**From:** Jeanie Bourke <jmb@portlandmaine.gov>  
**Sent:** Friday, July 22, 2016 8:56 AM  
**To:** Jill Johanning  
**Cc:** Laurie Leader  
**Subject:** Re: Portland Permit App

Attached is what I have so far for a bathroom renovation in a condo to make it accessible for the owner to come home. The scope is very limited by due to existing conditions; however the plan does call for removal of a small section of wall to create a new alcove for the sink.

AEI | OMARK RESIDENCE
 PORTLAND, ME
 BATHROOM PLAN

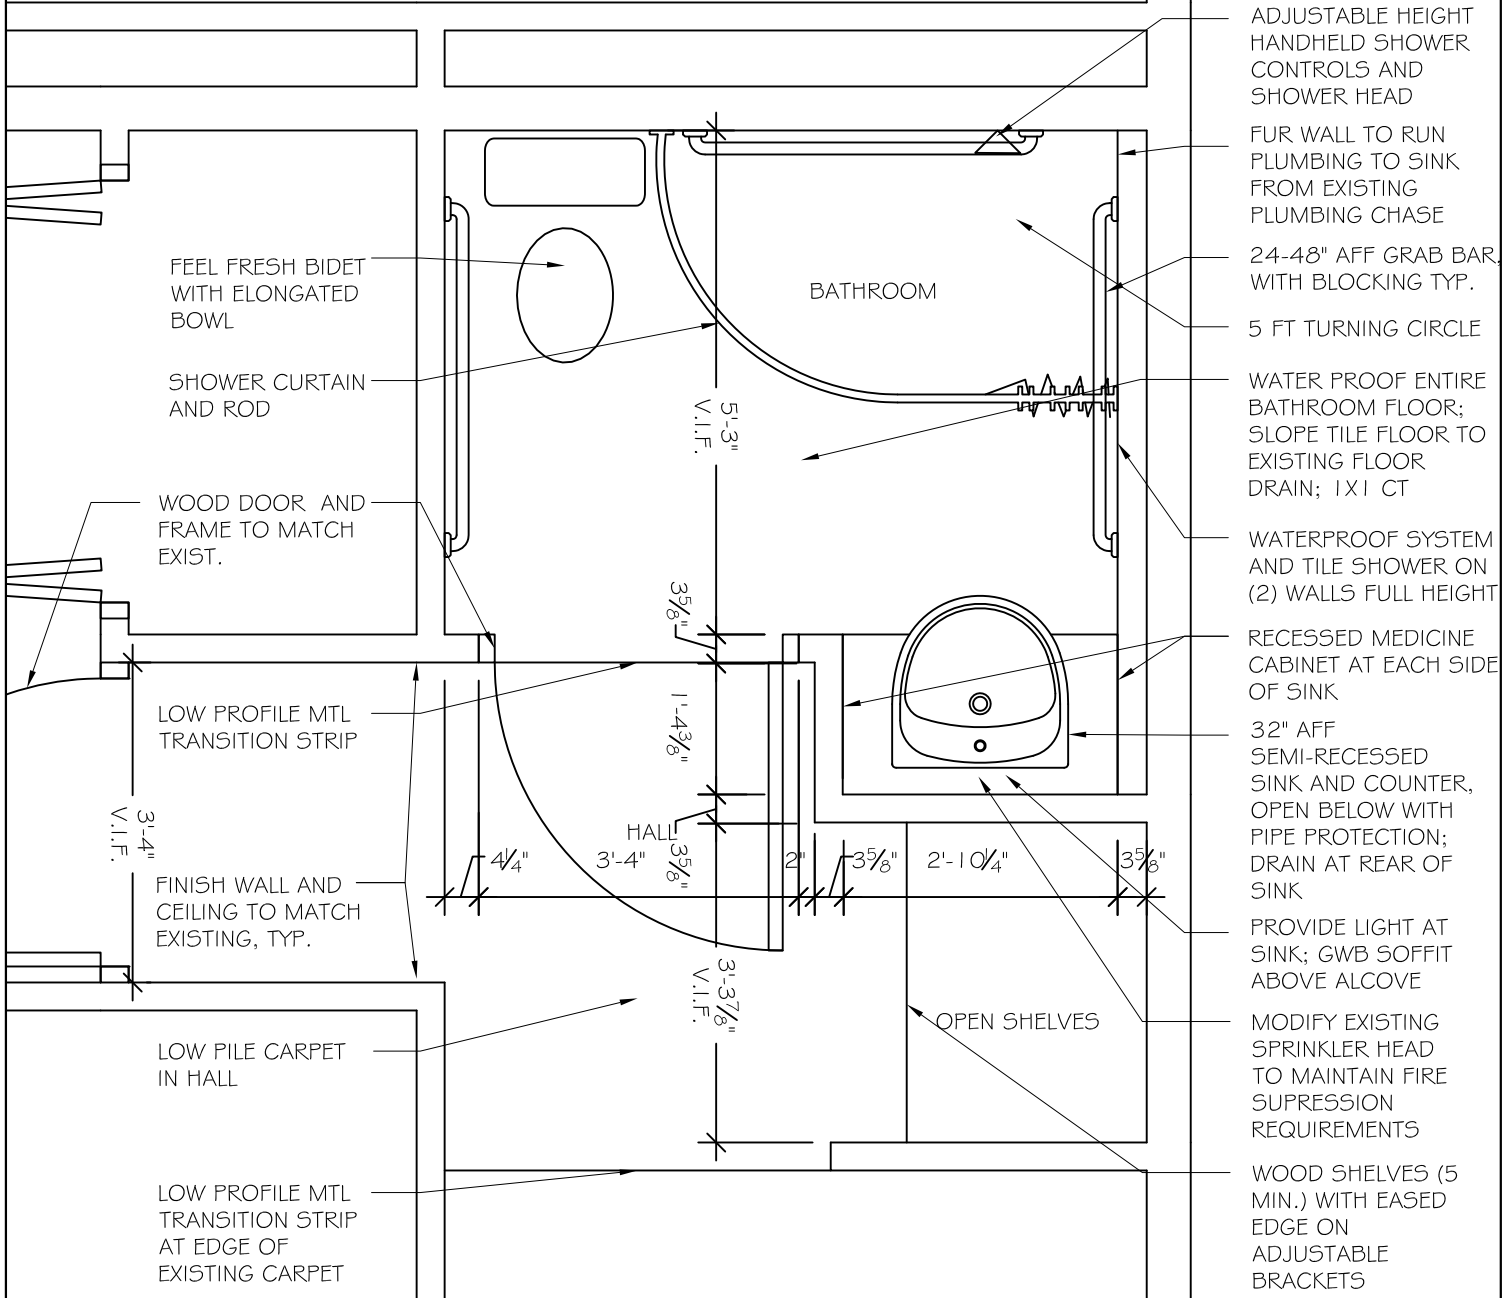
1. On the application, the CBL for the property tax ID is **002 A 007H02**.
2. In the description, please include the floor level, and it may be good to include that this is for accessibility.
3. Please indicate the materials used for the new bathroom walls, should be steel studs in this building and gyp.
